Response to REP8-096 9.13 Sizewell C Coastal Defence Design Report from EDF / Cefas by Bill Parker IP20026713

Outlined below are my comments and observations with regard to the Deadline 8 document issued by EDF / Cefas with regard to the coastal defence design report [REP8-096]. I have grave concerns both whether this proposal is fit for purpose and whether the recent changes proposed will exacerbate the vulnerability of this site.

SECTION @ F - F CONSTRUCTION SITE - DURING CONSTRUCTION OF INITIAL SEA DEFENCE

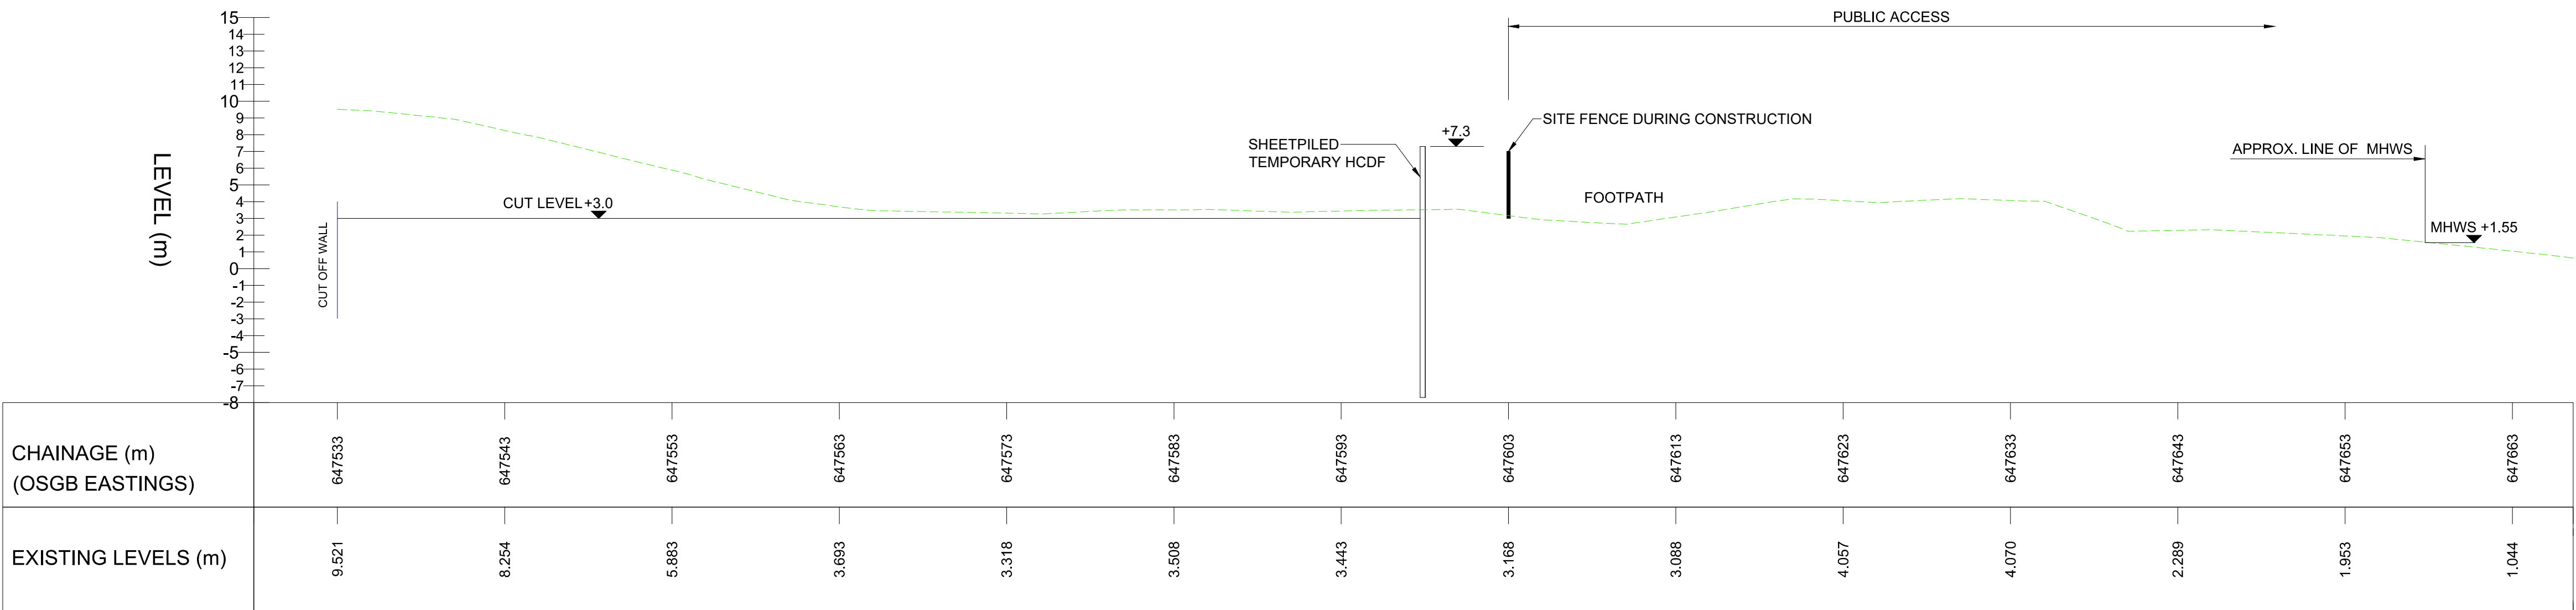
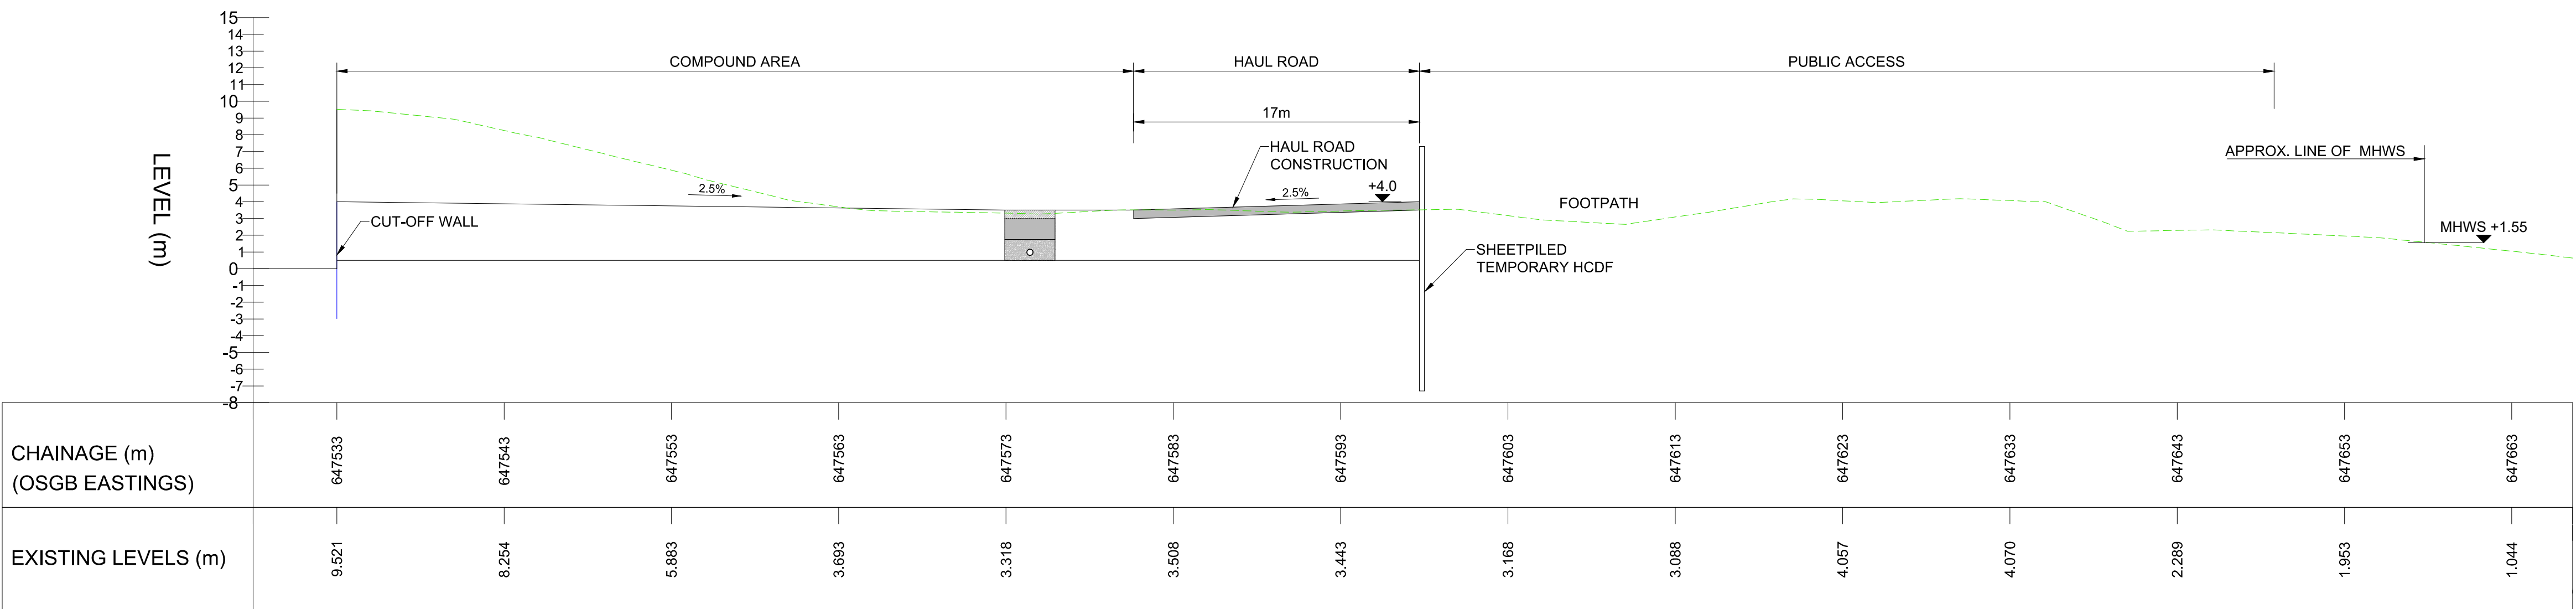
- 8) Temporary HCDF – In Fig 3-2 Temporary HCDF, Typical Cross section it appears that the structure will be only 3m above ground level. I would question if this is high enough to be confident that it provides adequate protection. It also functions as a shield to beach users from the haul road to the west of the defence. In view of the proximity, size of vehicles and scale of works being proposed I would question if this is sufficient?

SECTION @ D - D - SEA DEFENCE
SCALE 1:250

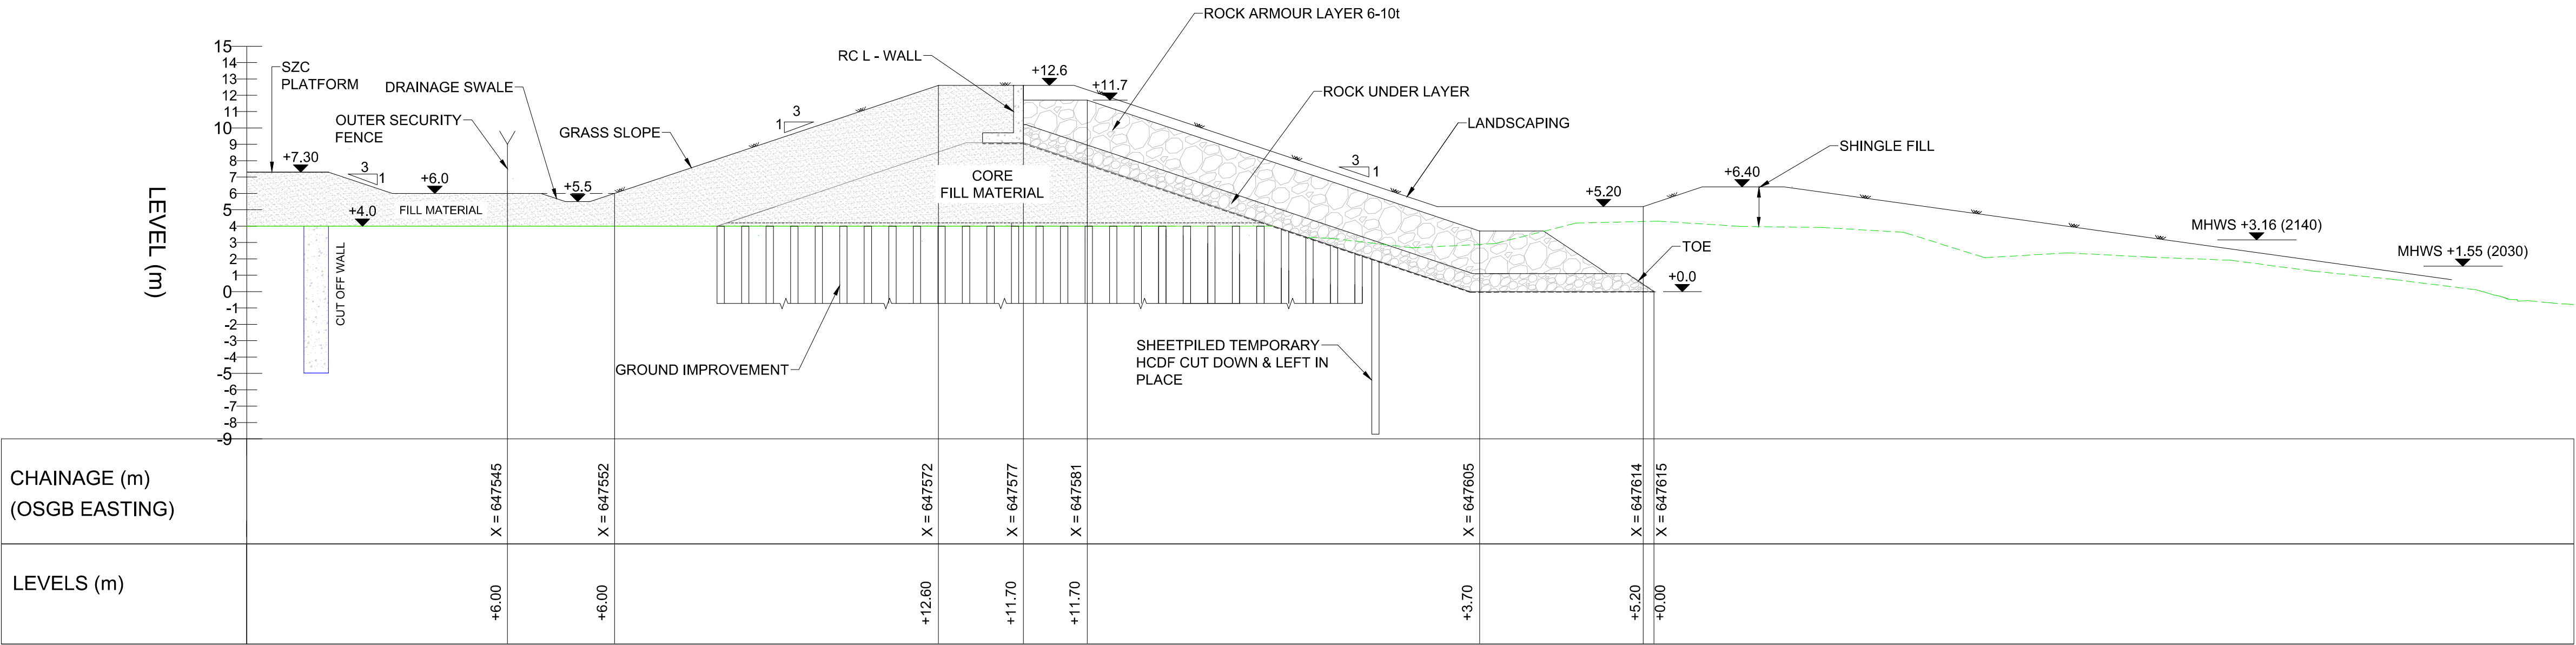
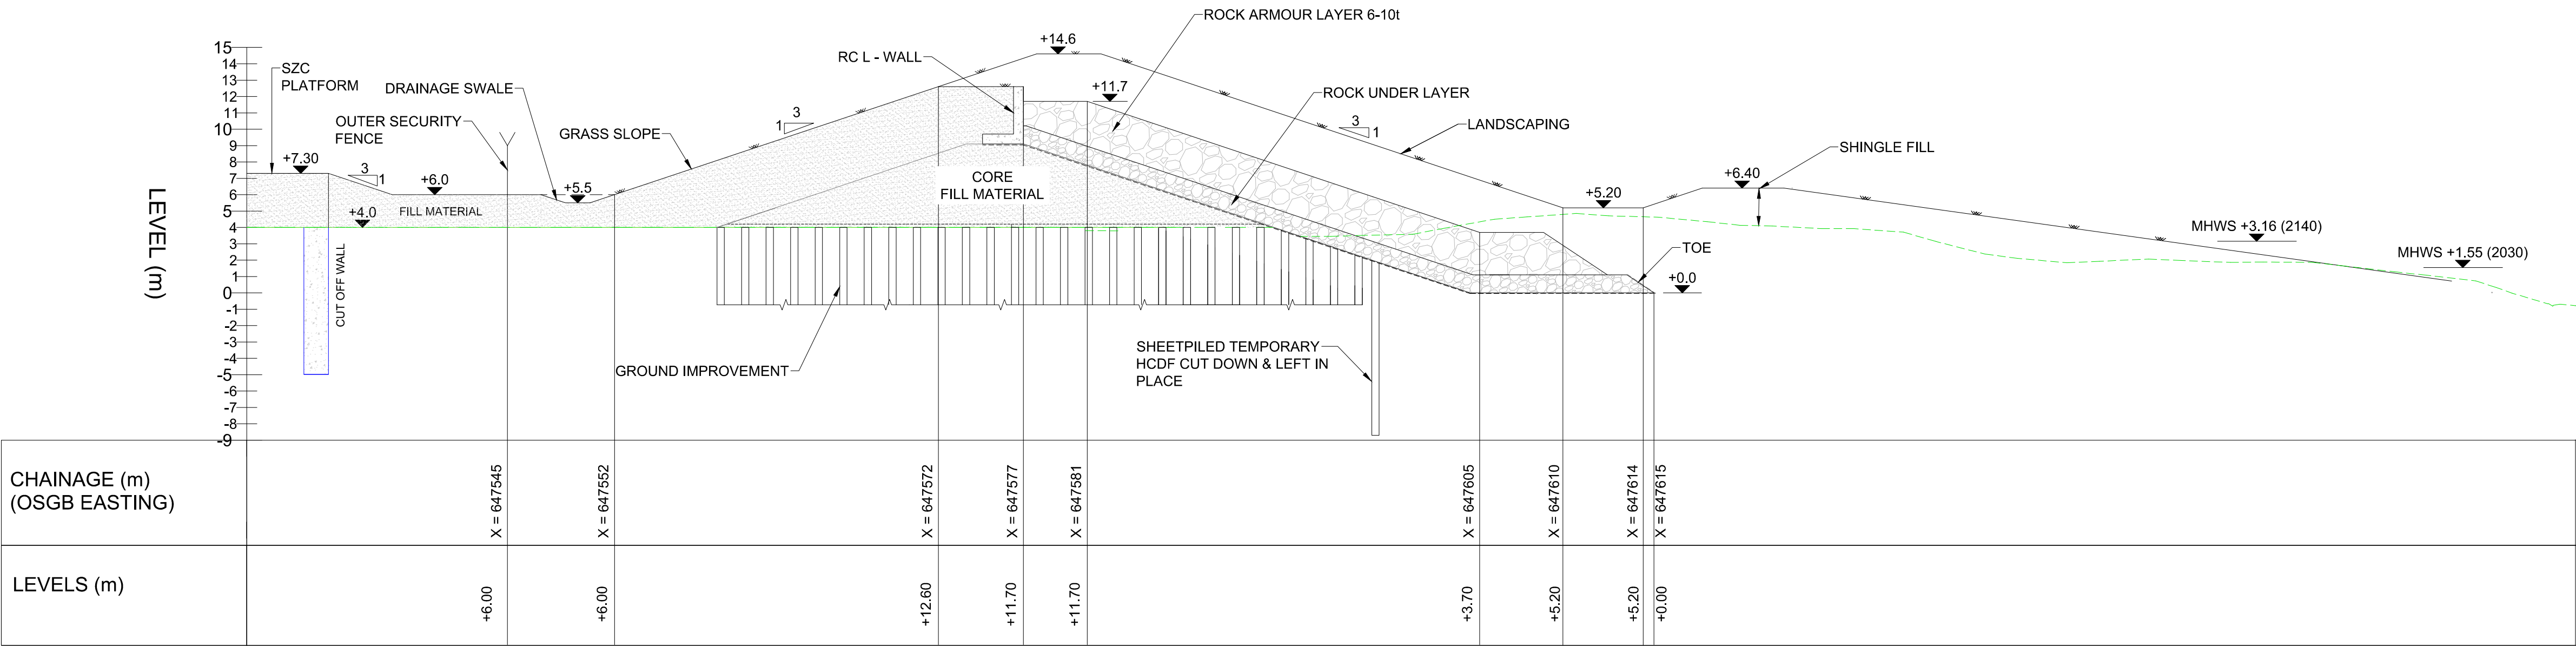
- 10) Figure 3-5 Permanent Sea Defence, Typical Cross-section... I note that the General Cross Section (assumed to be mid-way along the structure ref Fig 3-1) is in grey (unlike the lower part of the diagram) which makes examination impossible. This is clearly deliberate by EDF / Cefas presumably to avoid detailed critique this is unacceptable at this stage of the process.

What is clear is that the toe of the rock armour is only at +0.0 AOD and that isn't even the lowest point of the main defensive structure, the 6 to 10 tonne rock armour blocks. The lowest layer appears to be an undescribed smaller material layer. Questions on vulnerability to undermining remain especially as in para 3.10.10 there is a statement that:

*'numerical modelling of the beach storm response indicates that the toe of the HCDF would not be at risk of being undermined in a design basis of a 1:10,000yr storm event provided it is set at 0.0m or lower'*

integrity of the HCDF. In view of Cefas already admitting to the very limited time period that modelling is useful (for as stated in [APP-311]) it would seem an unwise and false economy to have such shallow base to the HCDF on its construction.
